From:
To: [Planning](#)
Subject: Planning application 6/2019/0217/MAJ - Northaw House
Date: 18 April 2019 09:39:28

Response to Planning application from Hertfordshire County Council (T and CP GDP Order 2015)

District ref: 6/2019/0217/MAJ

Proposal

Project Ref KMC-01	Rev 01
-----------------------	-----------

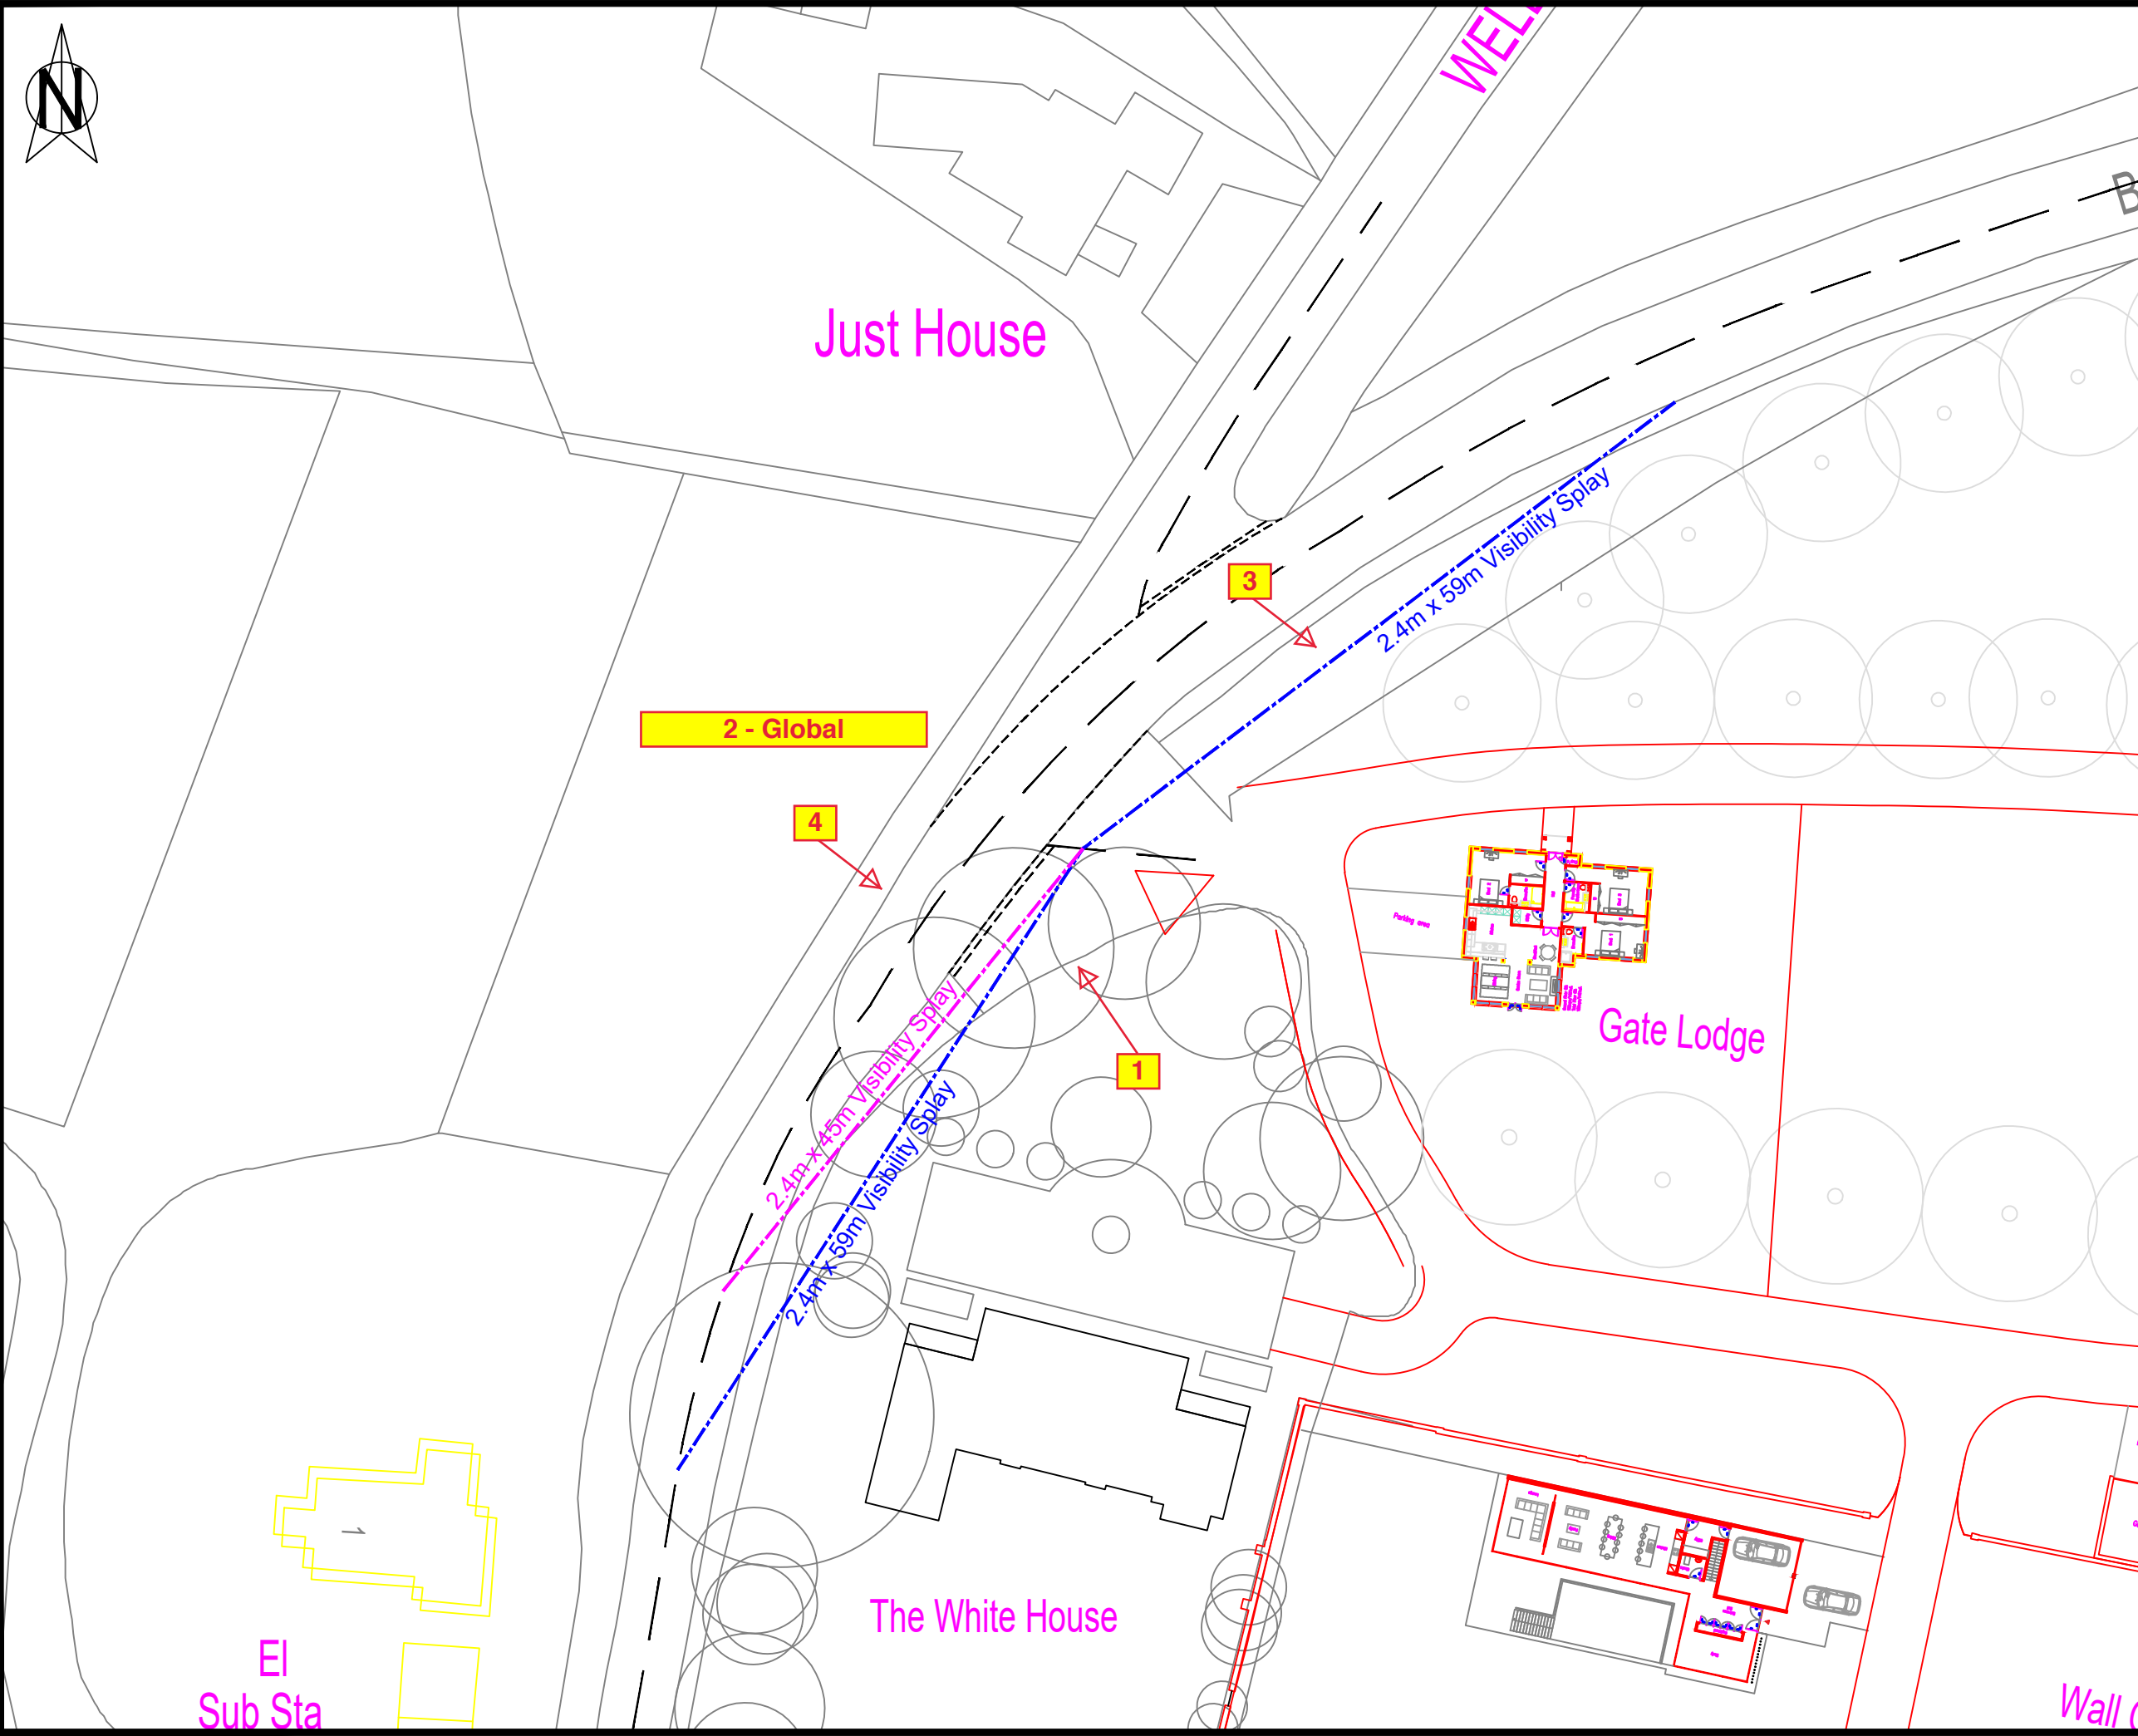
Visibility, from the western access, is assessed as deficient to MfS standards for a 40mph road, however the application is supported by speed survey data indicating that 85%ile speeds are measured at 35mph. It is therefore recognised that the western access, despite a number of minor improvements (junction radii / improved road marking / slow markings on approach to the bend) has visibility beneath that required. The use of MfS visibility splays is correct recognising that the County Council identifies within Roads in Hertfordshire: Highway Design Guide 3rd Edition Section 1: Policy Information and General Guidance Chapter 1 that MfS recommendations may be used on roads with 37.5 mph (60kph) or lower actual (85th percentile) speeds.

It is recognised that drawing KMC-01 rev 01 incorrectly identifies the visibility splay. Visibility splays, as directed by MfS are measured to the kerb face, whereas KMC-01 measures to centre line. At this point on Coopers Lane no physical measure prevents vehicles overtaking. Actual visibility would therefore be measured as 49m to kerb face, or 52m to a point that vehicles would be expected to be (MfS2).

3) Prior to the first occupation of the development hereby permitted a visibility splay shall be provided in full accordance with the details indicated on the approved plan number (KMC01 rev 01 and KMC02 Rev 01). The splay shall thereafter be maintained at all times free from any obstruction between 600mm and 2m above the level of the adjacent highway carriageway.

Drawing Ref KMC001 - 01 (Sheet 2 of 2)	Rev 02
---	-----------

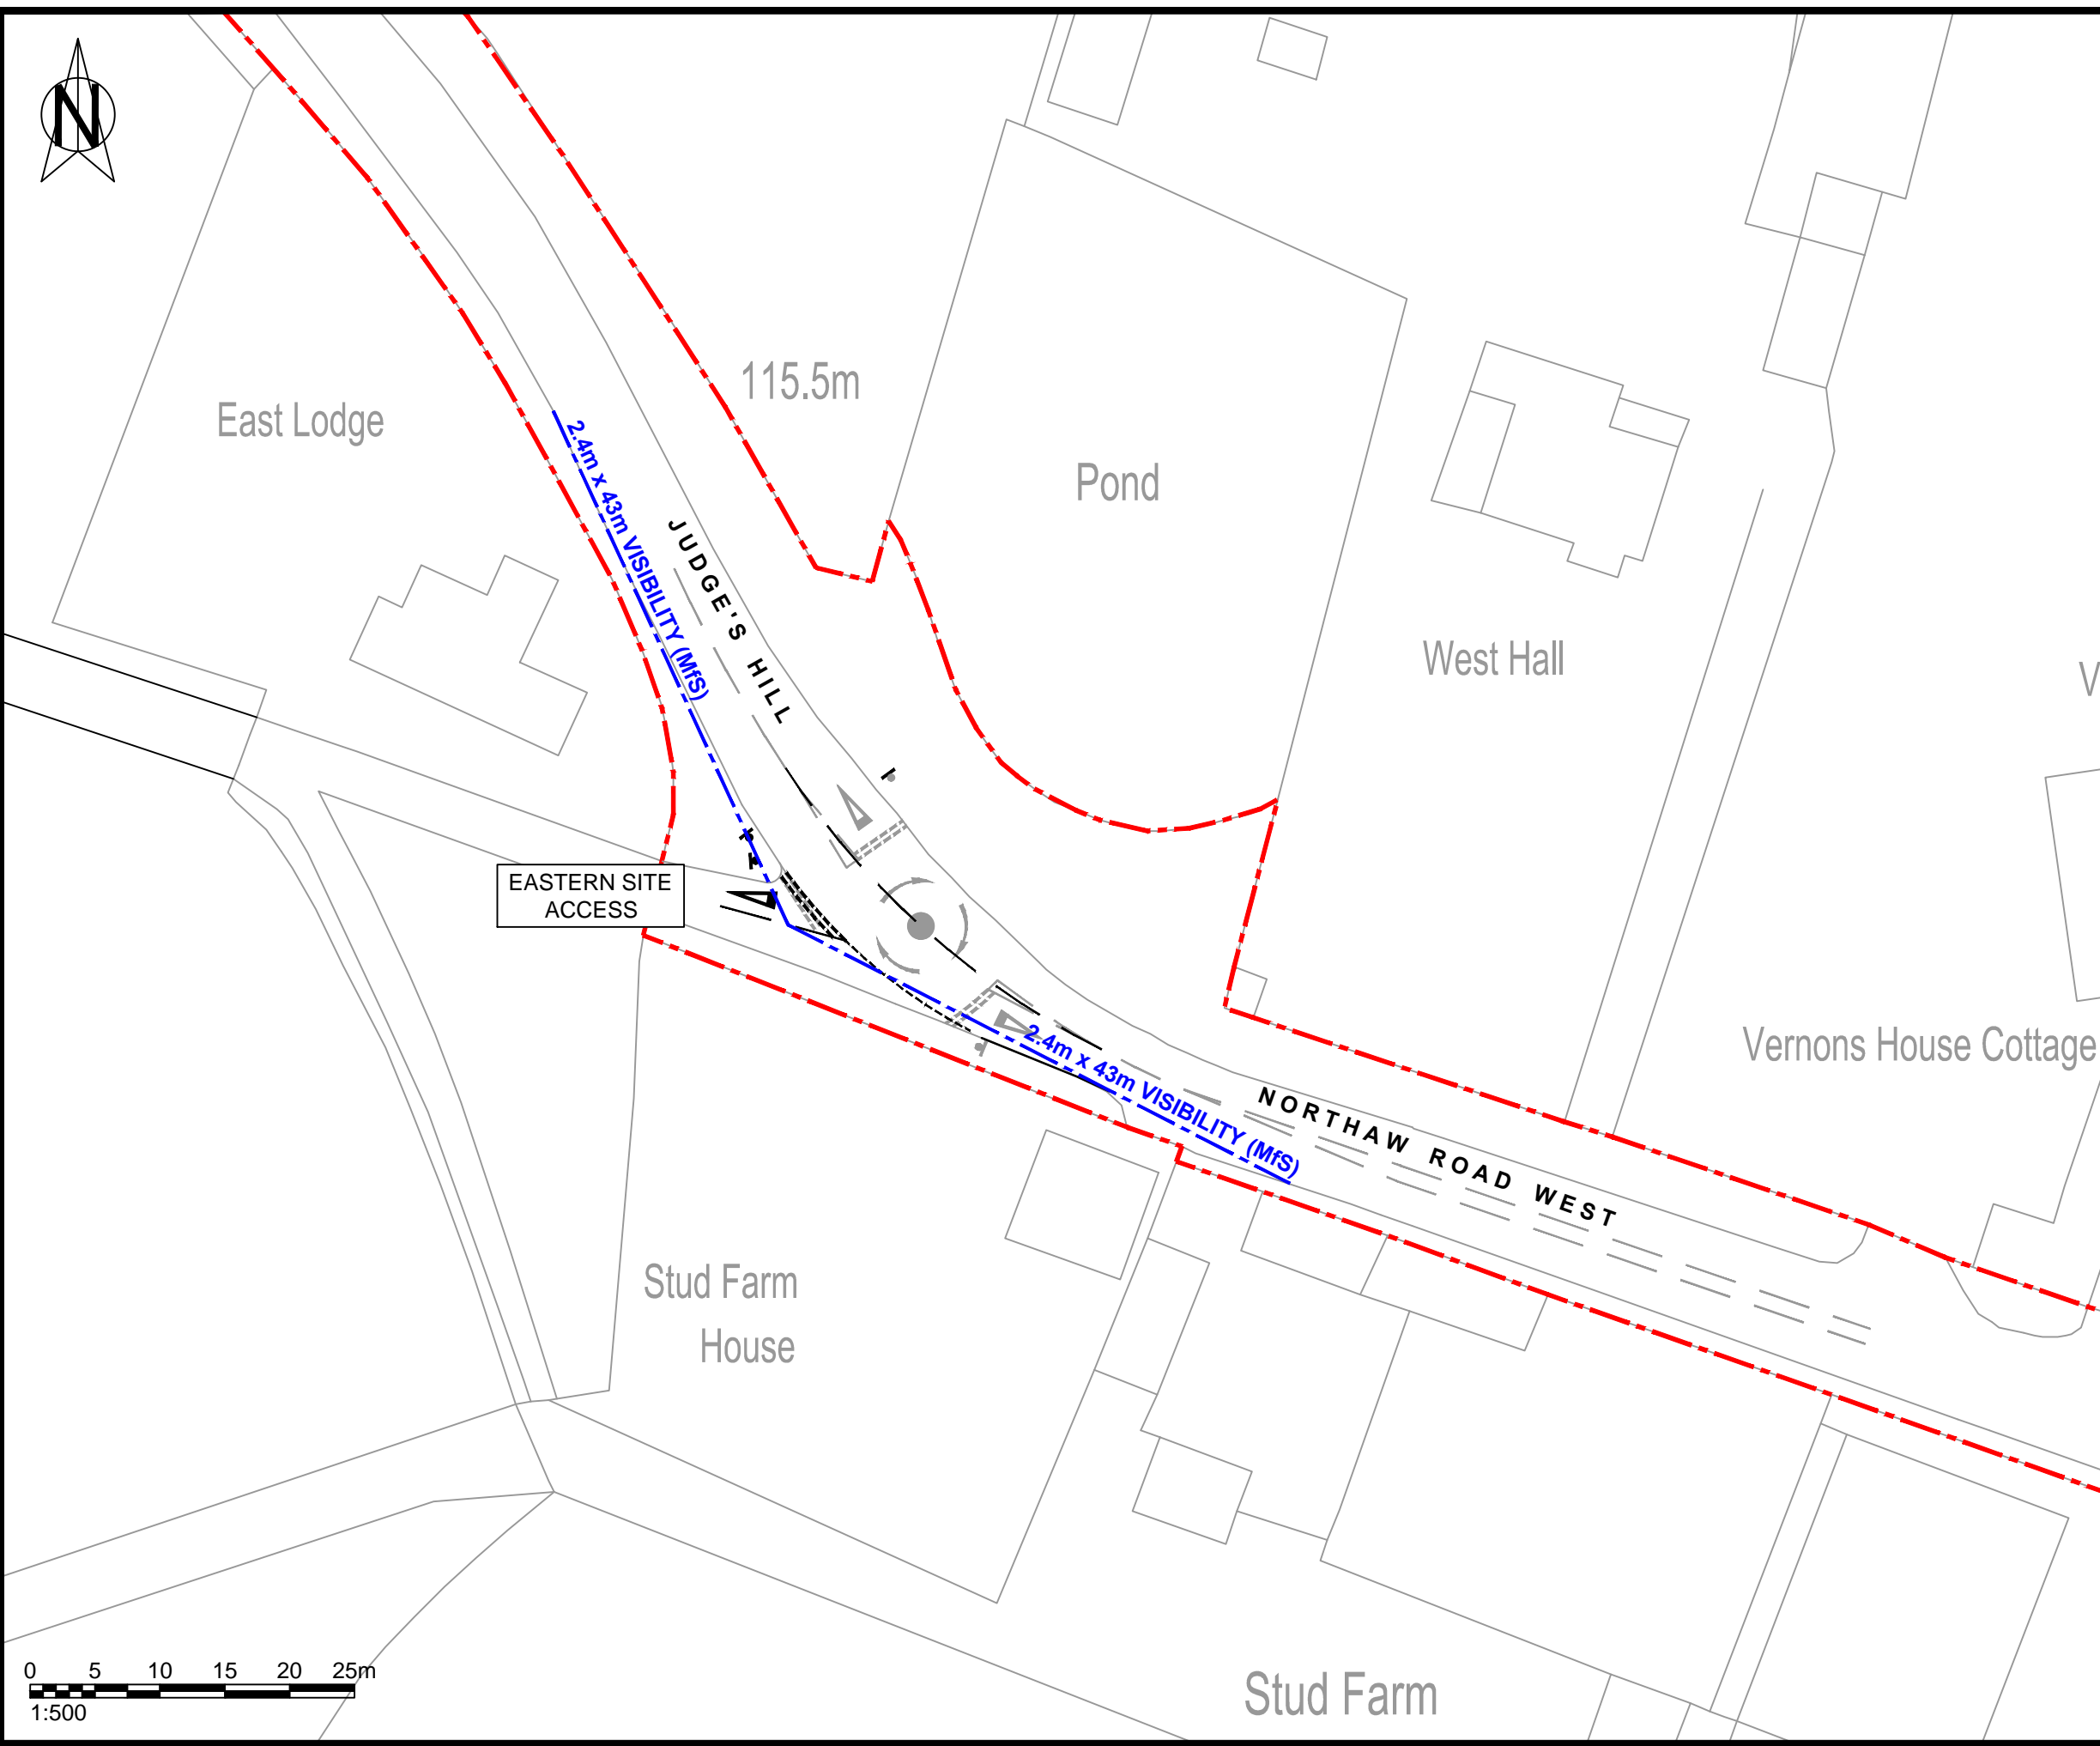
Visibility from the eastern access is sufficient for the posted vehicle speeds (43m SSD adjusted in both directions). The proposed junction changes (removal of miniroundabout and replacement with priority junction) is deemed acceptable to the Highway Authority. Such improvements also include hardening of carriageway edge for improved definition, and replacement signage (to TSRGD) for road humps, and associated lining.

Improvements to the Western Access are also found to be agreeable to the Highway Authority. Access width is reduced to encourage slower vehicle speeds into the site, whilst simultaneously reducing the distance that pedestrians are within a point of conflict with vehicles. Lining on highway shall be refreshed (slow markings / centre line).

i) Concurrent with the improvements to points of access (as condition 2 below), all off-site highway works shown on drawing KMC001-1 Rev 2 shall be delivered to the satisfaction of the Highway Authority, and shall also include improvements to NE bound and SW bound bus stops local to the site to provide Kassel kerbing. Reason: To ensure that sustainable travel options associated with the development are promoted and maximised to be in accordance with Policies 1, 3 and 6 of Hertfordshire's Local Transport Plan (adopted 2018).

2) Prior to the first occupation hereby permitted vehicular accesses (indicated for improvement on drawing number (KMC001-1 rev 2) shall be reduced in width and provided with kerb radii as shown. Prior to use arrangements shall be made for surface water drainage to be intercepted and disposed of separately so that it does not discharge from or onto the highway carriageway.
